From: Chris Lawrence <[REDACTED]>
Sent: 27 January 2014 17:07
To: Simon Davis
Subject: Re: AL/73/13 Sack lane
Attachments: Evergreen Cottage legal Opinion.pdf

From: Chris Lawrence <[REDACTED]>
Sent: 04 December 2013 12:12
To: Simon Davis
Subject: Re: Planning Consultation on: AL/73/13/

PROJECT		Conversion of existing barn at Sack Lane Dairy, Lidsy	
SUBJECT		Site Plan and Location Plan	
SCALE 1:200 & 1:1250	DATE Mar 2013	DRAWING No	Rev A
DRAWN	CHECKED	2012 / 01 / 03

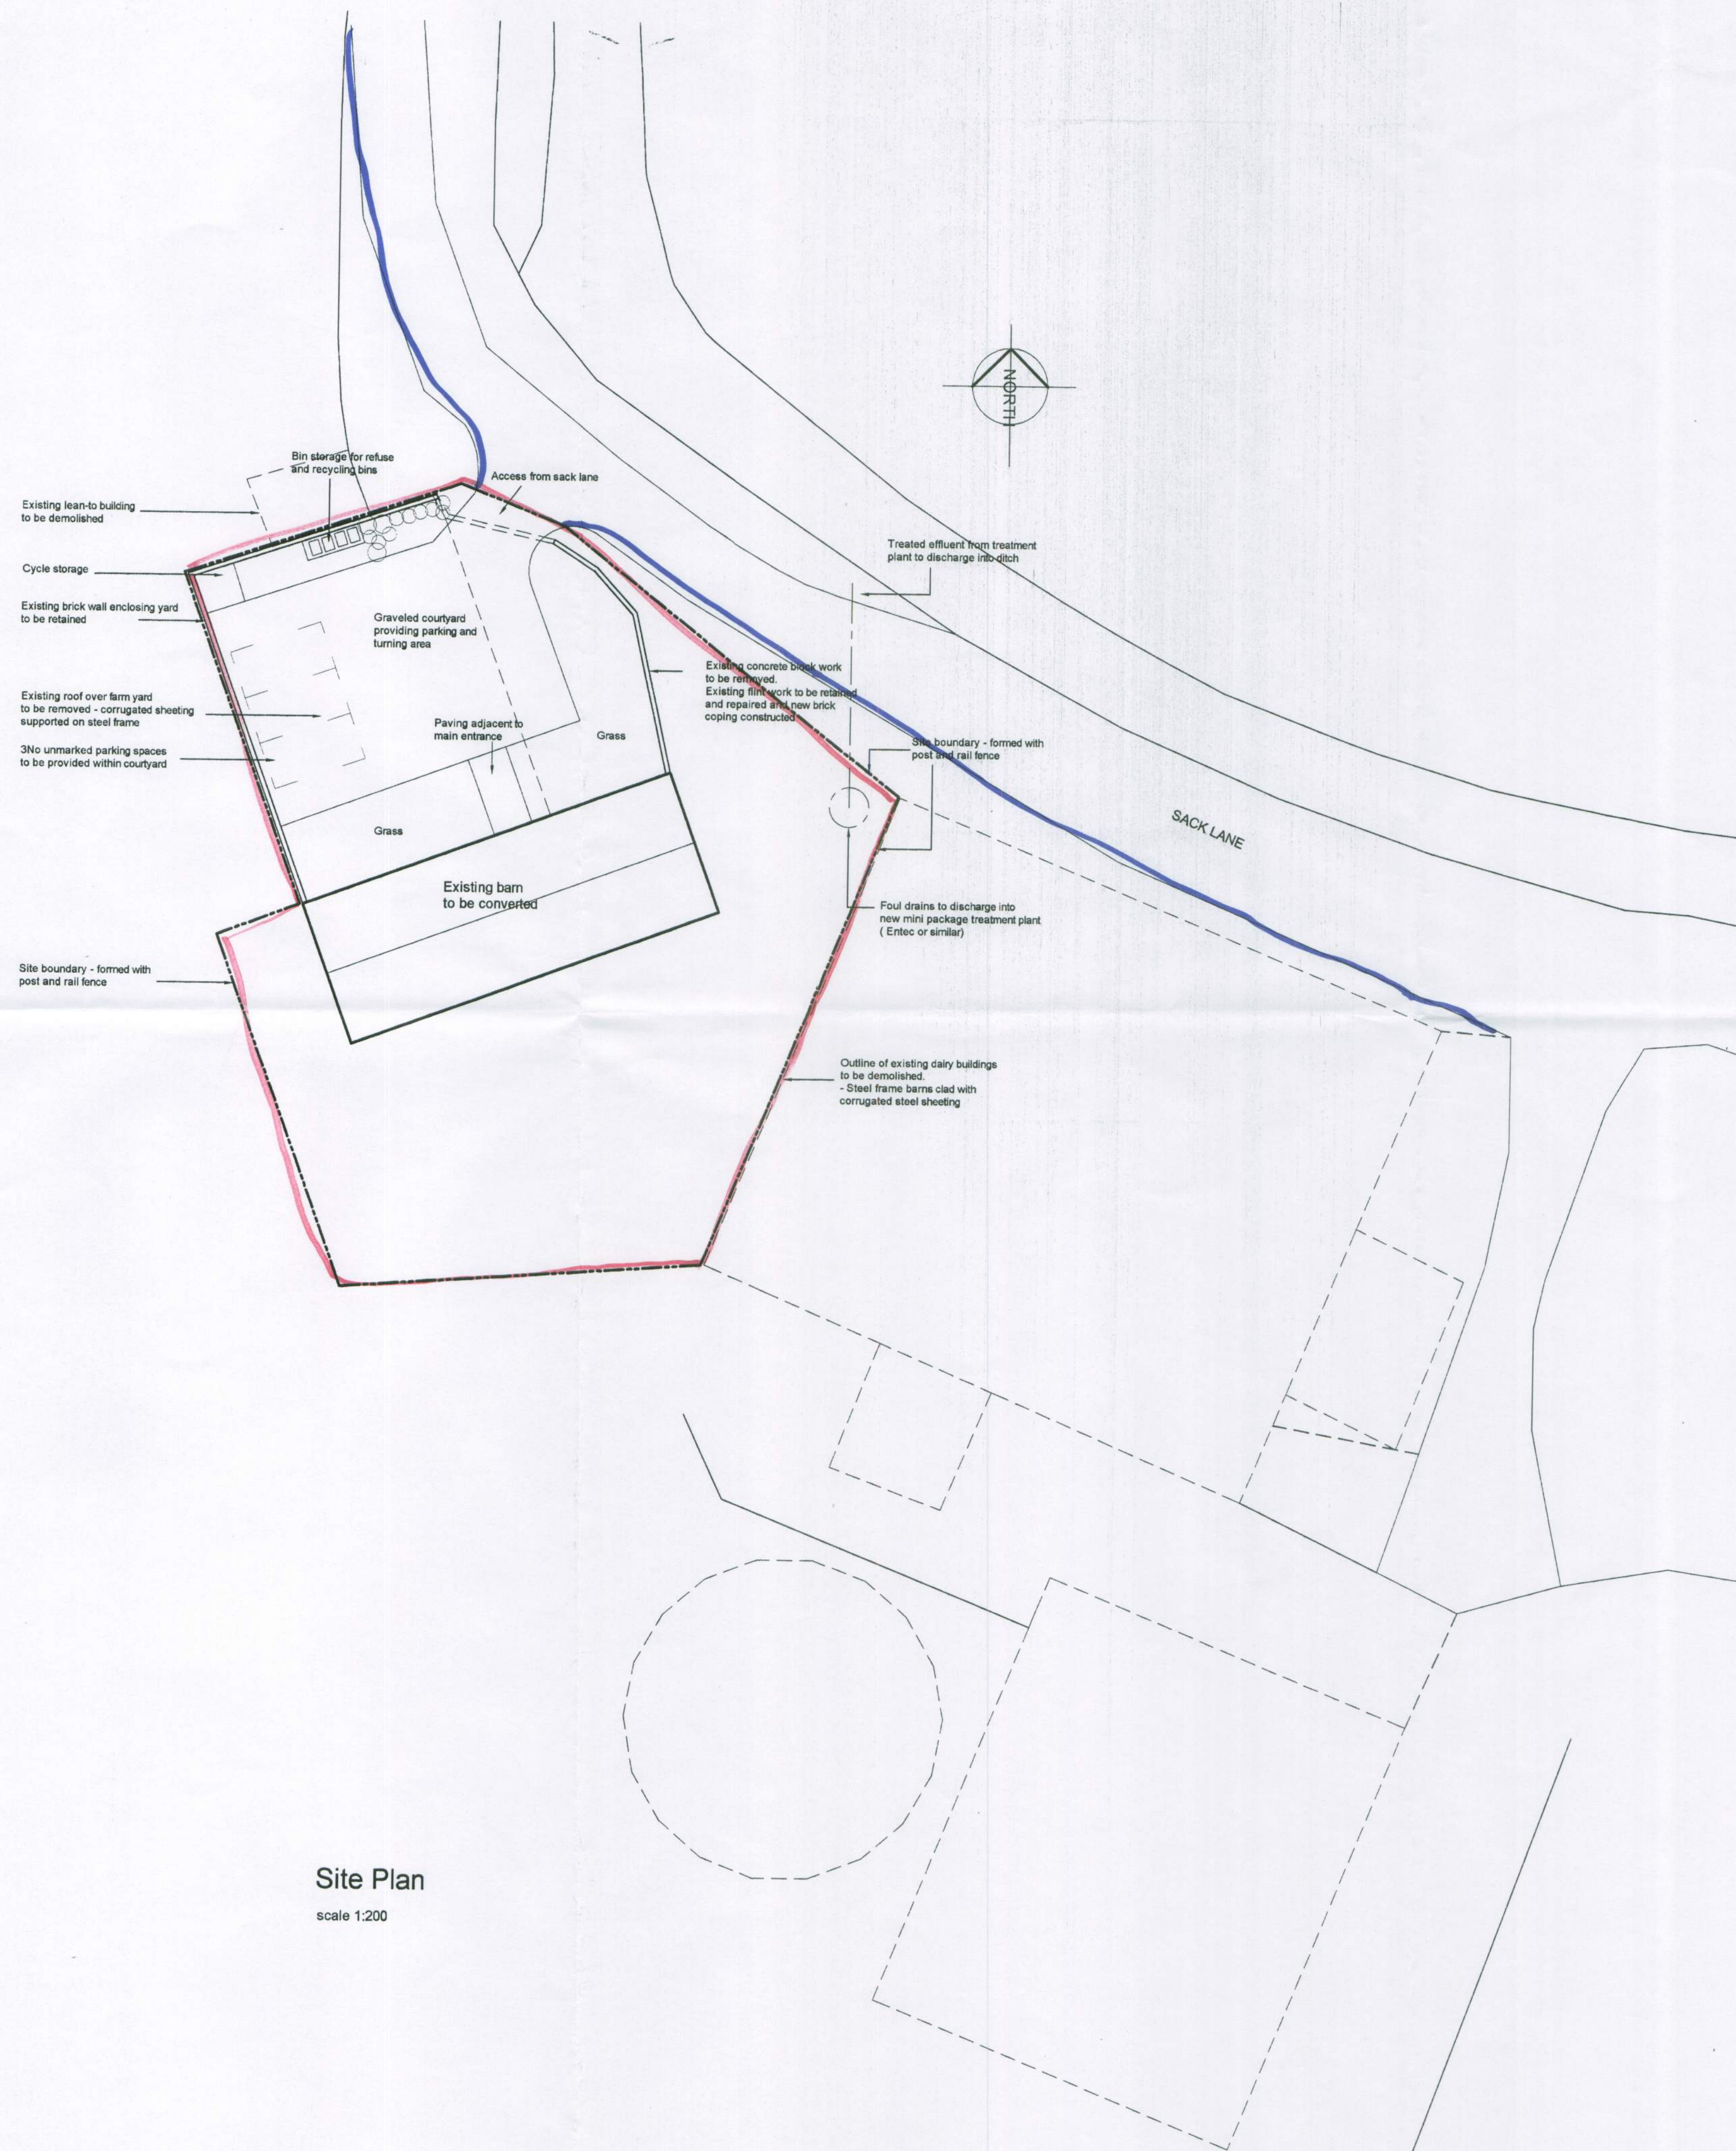
Earlier today you suggested that you had concerns regarding the extent of the garden area. I have spoke to you various times over the past 6 months and no such concerns have been raised at all. However, if you would prefer a smaller curtilage can you please advise me which parts you would like excluded and I will revise the site plan. As I am sure you will appreciate It would be most unreasonable at this stage and having regard to previous discussions, to introduce curtilage as a totally unnecessary reason for refusal.

REVISION			
PROJECT			
Proposed conversion of existing barn at Sack Lane Dairy, Lidsey.			
SUBJECT			
Proposed Plans and elevations			
SCALE	DATE	DRAWING No	Rev
1:100	Mar 2013	2012 / 01 / 02	A
DRAWN	CHECKED

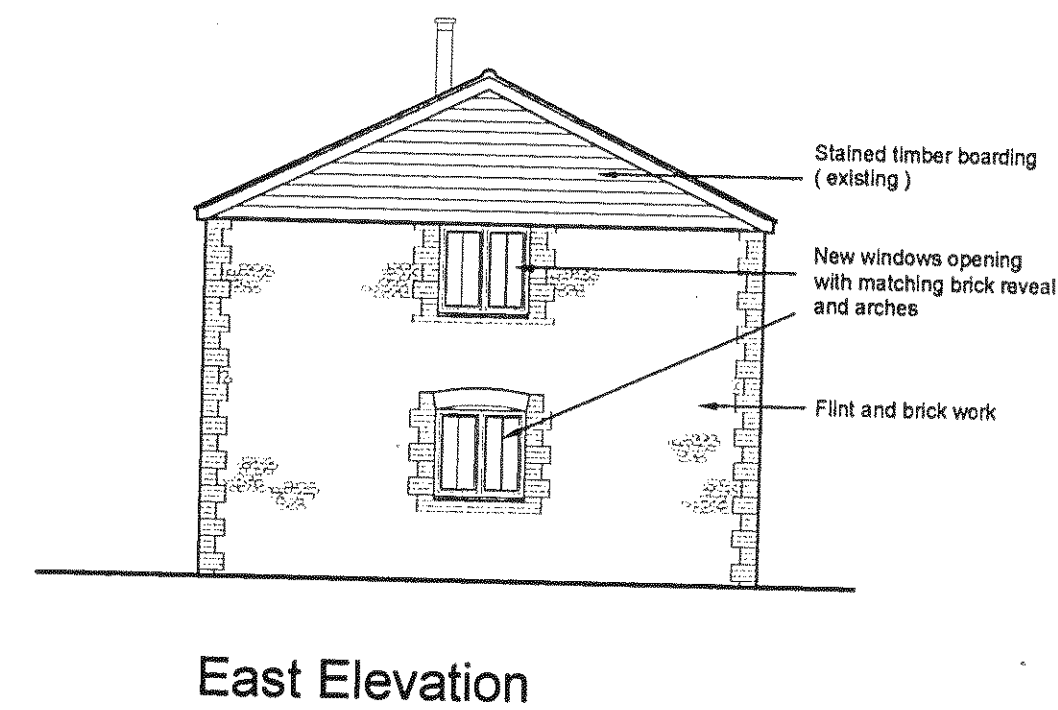
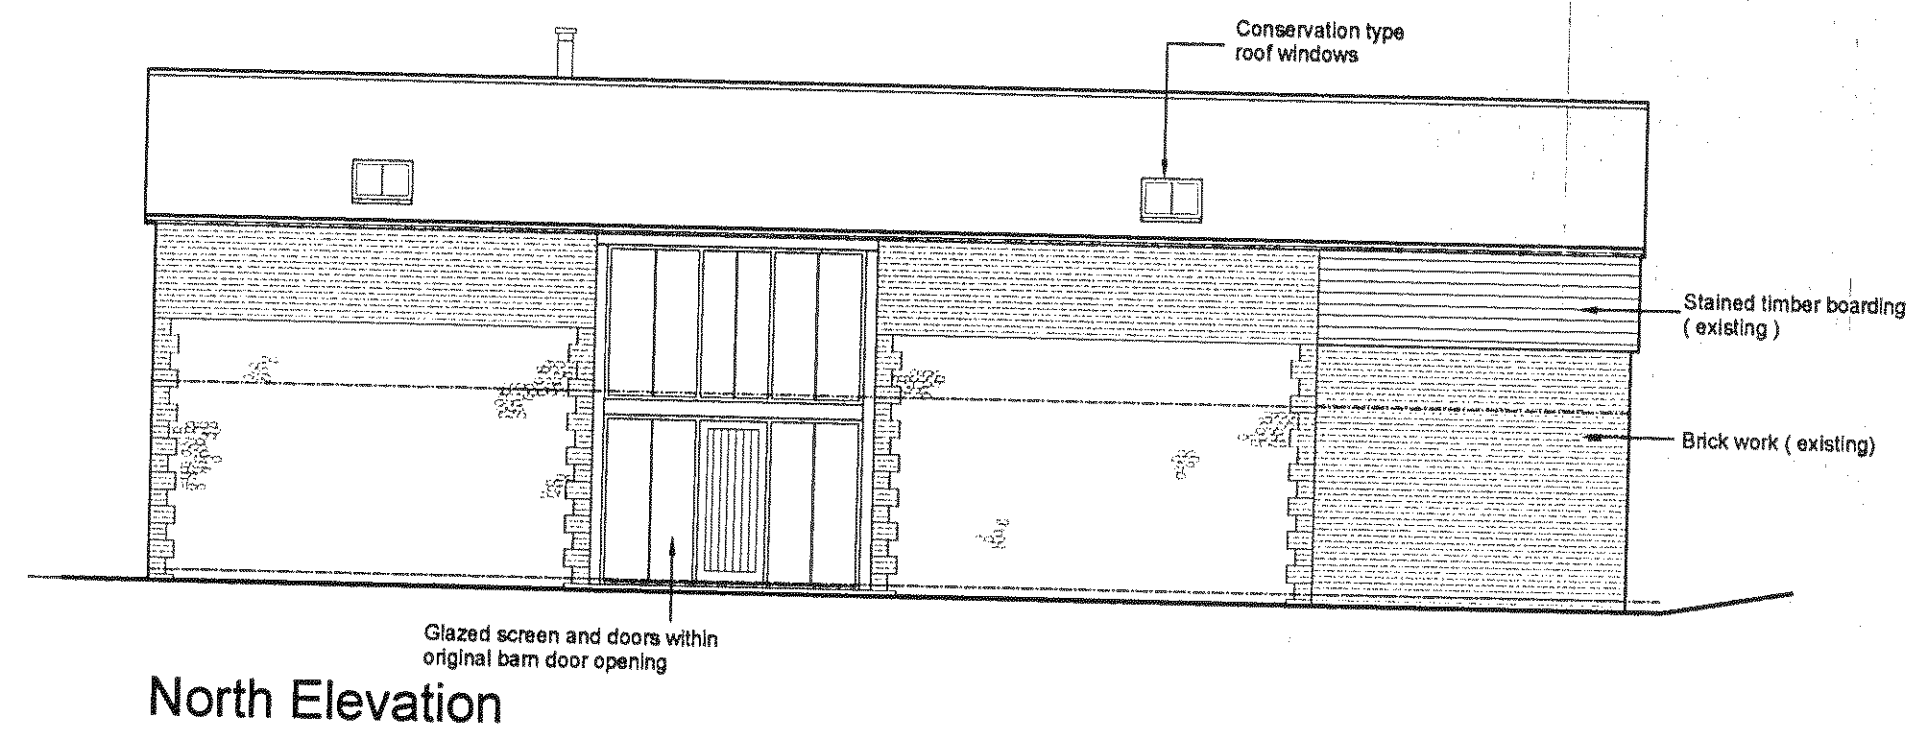
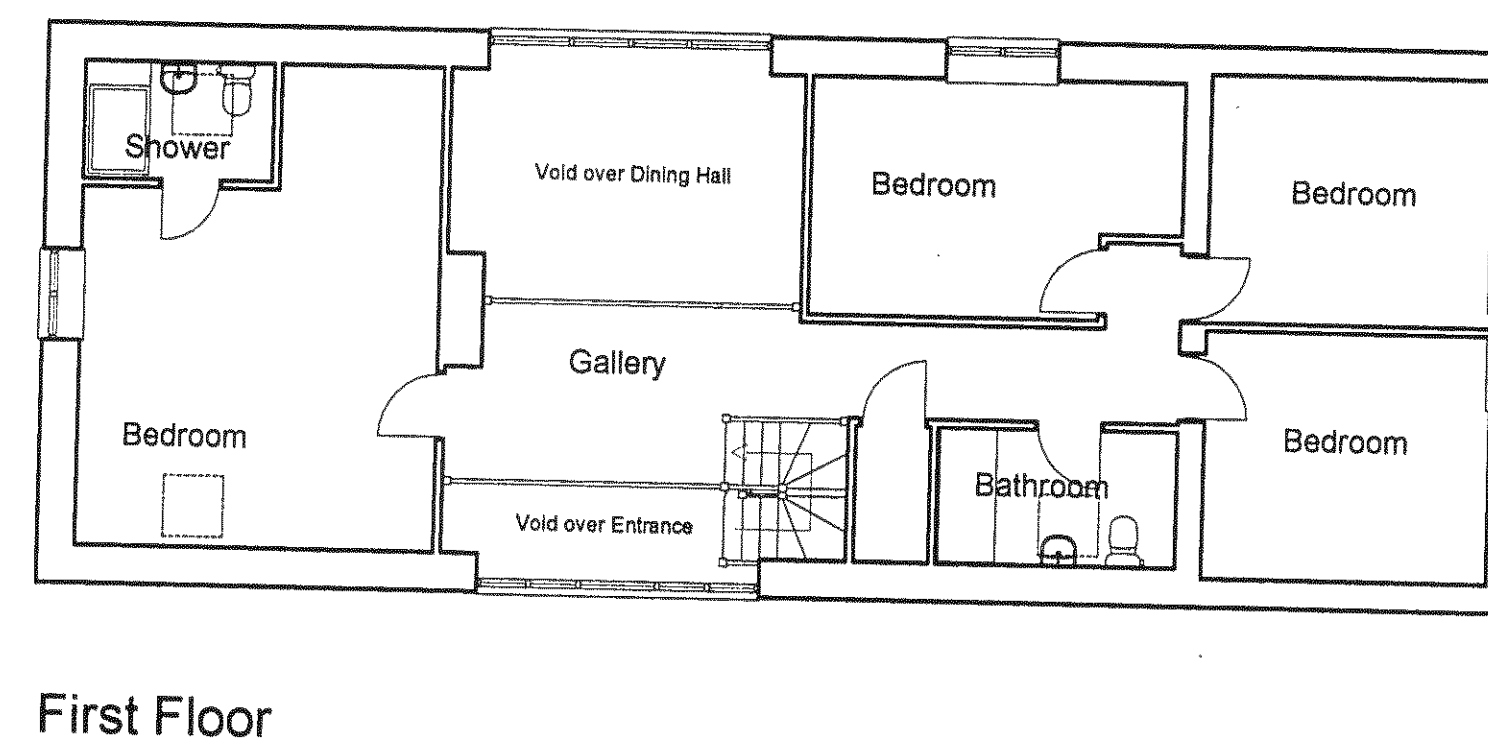
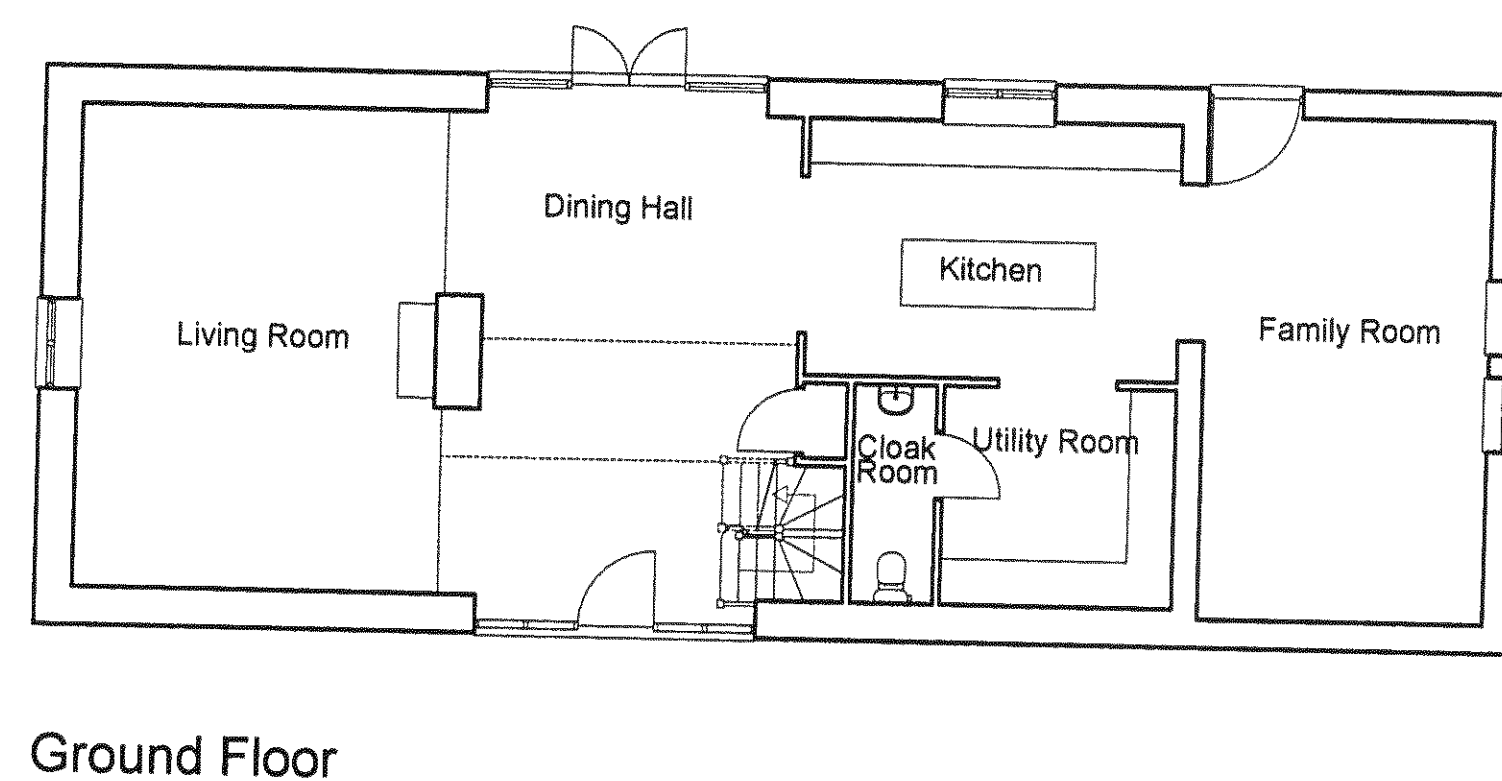
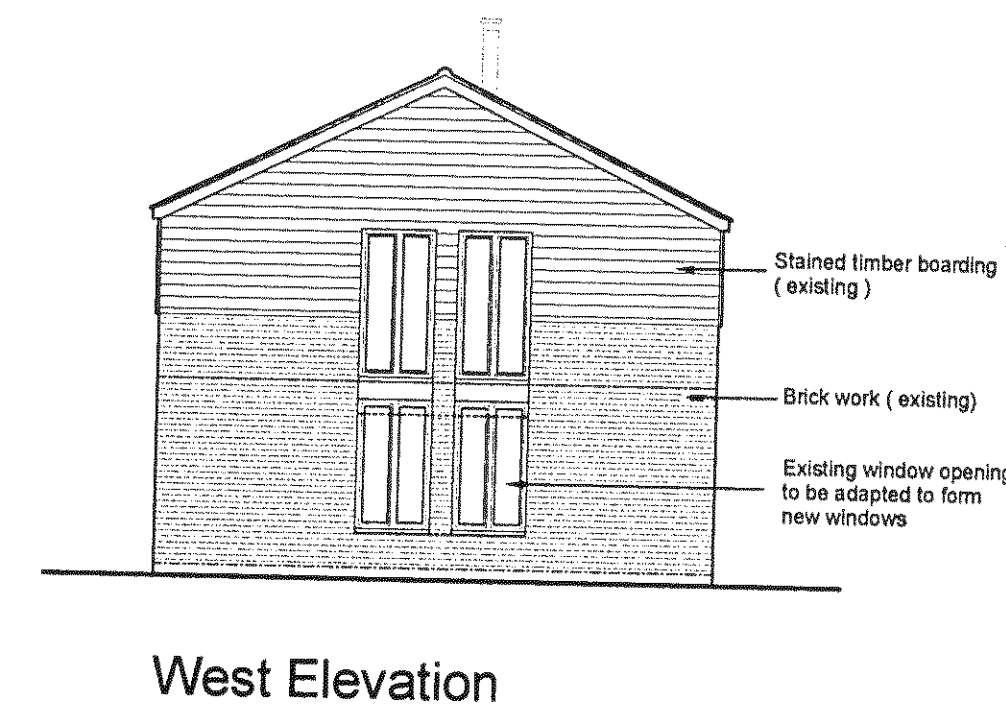
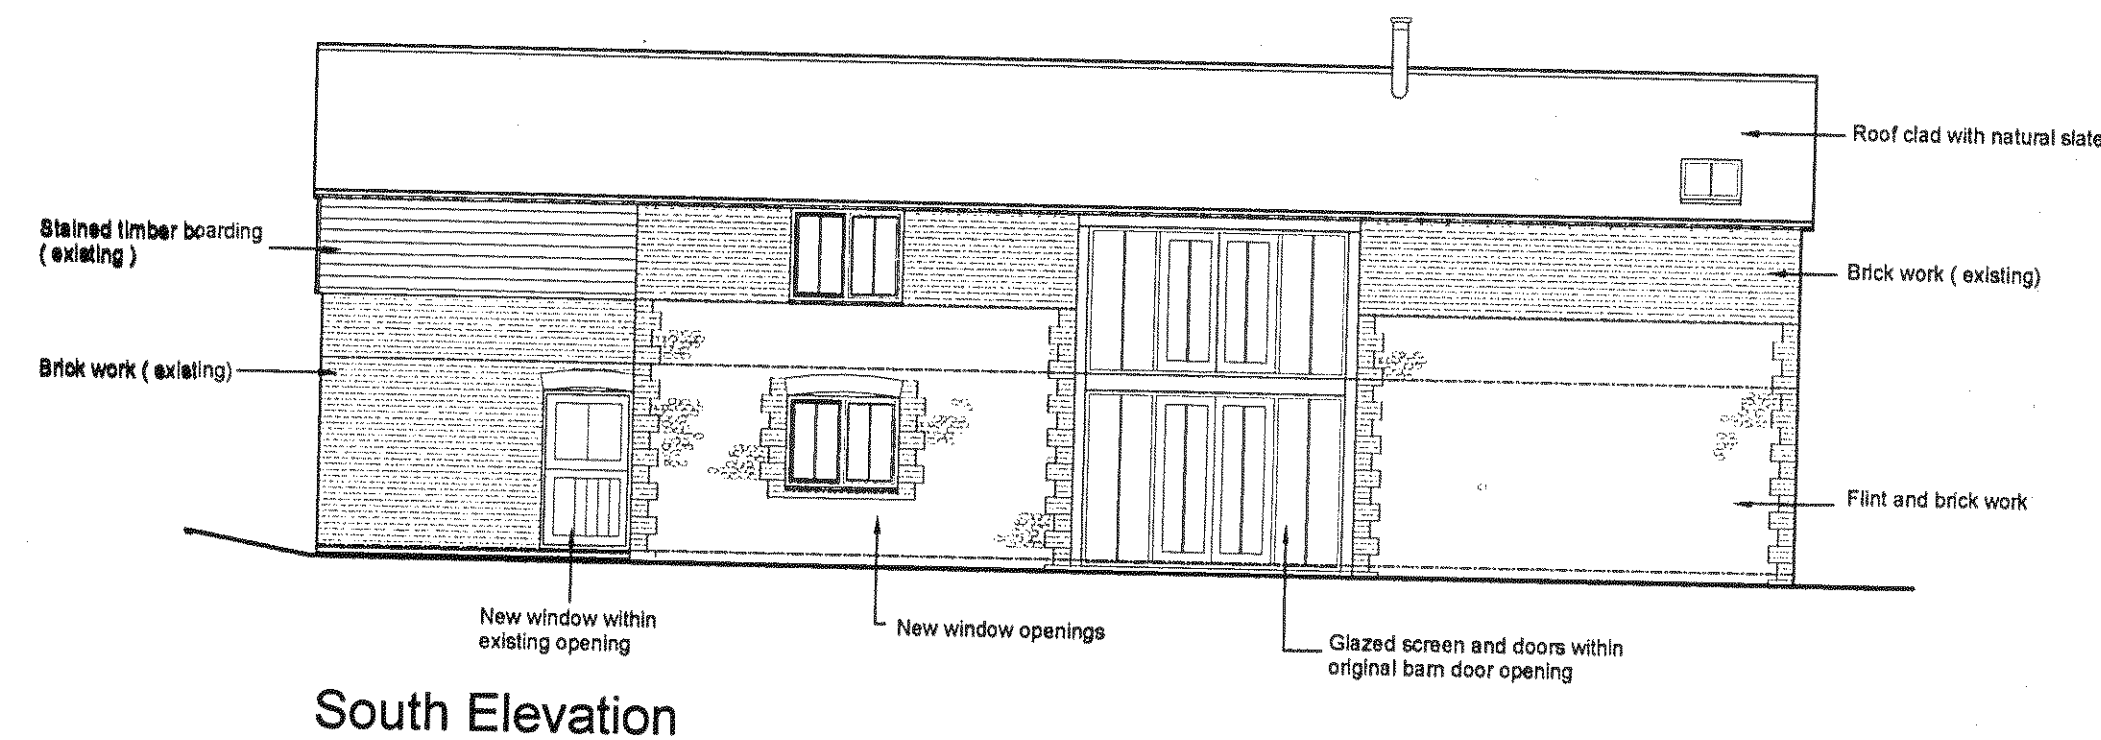
I have received the attached consultation response from our Historic Buildings Adviser. As you will, read, he is unable to support the application unless further changes are proposed in respect of the floor plans and elevations. I thought I would issue these to you now and see if your client is willing to make any or all of the amendments?
